To: Dineen, Richard W.; Sertich, Richard
Cc: Dourte, Richard H.
Subject: Lands of Twin Mountain...Sketch Plat at DRB today

This is my summary of the comments recived by Wayjohn Surveying, agent for Twin Mountain construction, for proposed development plans on Menaul between Edith & I25:

**CITY OF ALBUQUERQUE
PLANNING DEPARTMENT
April 11, 2007
DRB Comments**

**RE: Tract A-1, SPRINGER SPEECHLY PLAT TBK LANDS OF
TWIN MOUNTAIN/sketch**

SKETCH PLAT OF LOTS 1 AND 2 LANDS OF TWIN MOUNTAIN

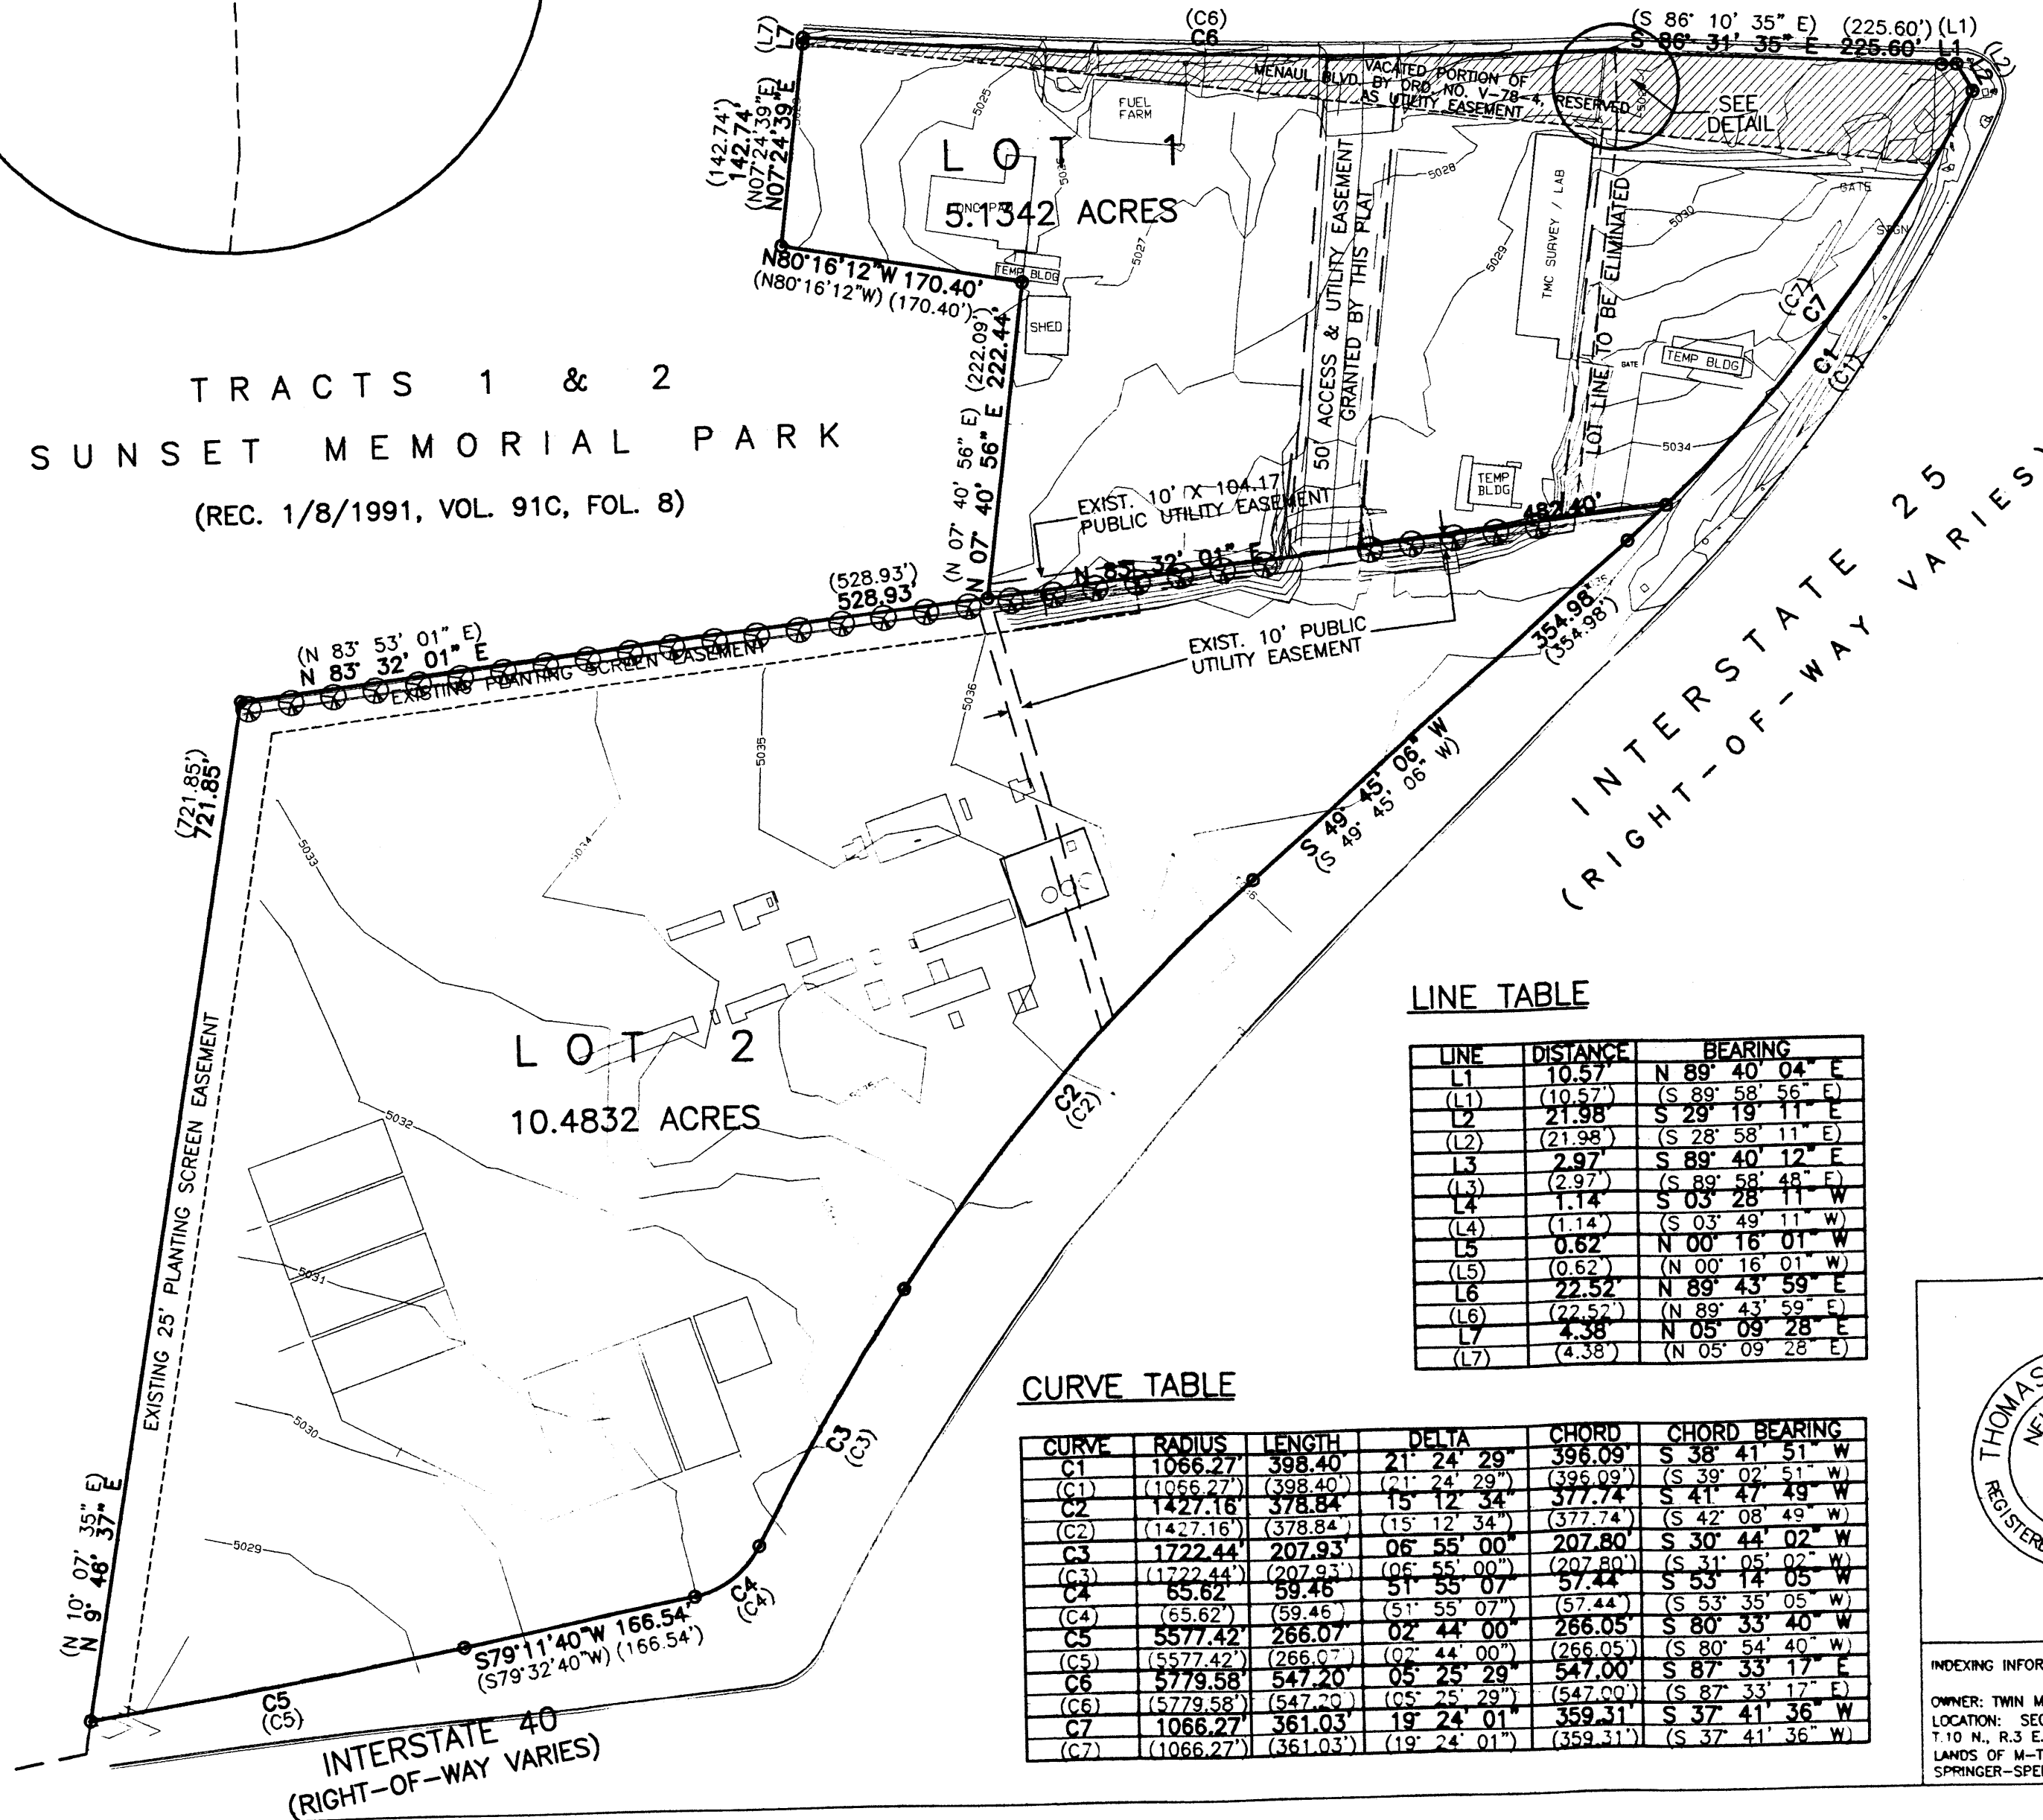
- The property is currently zoned M-1 with a portion in the NE corner zoned C-3. It is within the Martineztown Sector Plan boundaries.
- They want to re-configure the existing 2 lots to include the C-3 lot in the new northern lot of 5 acres. The remainder of the property, 10.5 acres is to remain as Twin Mountain Construction's site.

- They will need NMDOT approval to dump storm flows onto I-25 land. They may already have that approval. Neither the agent nor DRB knew for sure.
- Sidewalks along the frontage road & Menaul are required.

- 124 feet of R/W for Menaul is needed. Wilfred asked for a cross section to see what's there now.
- There is a concern about too many driveways onto Menaul and the median cuts.

A zone change is required to combine the C-3 property with the M-1 property.
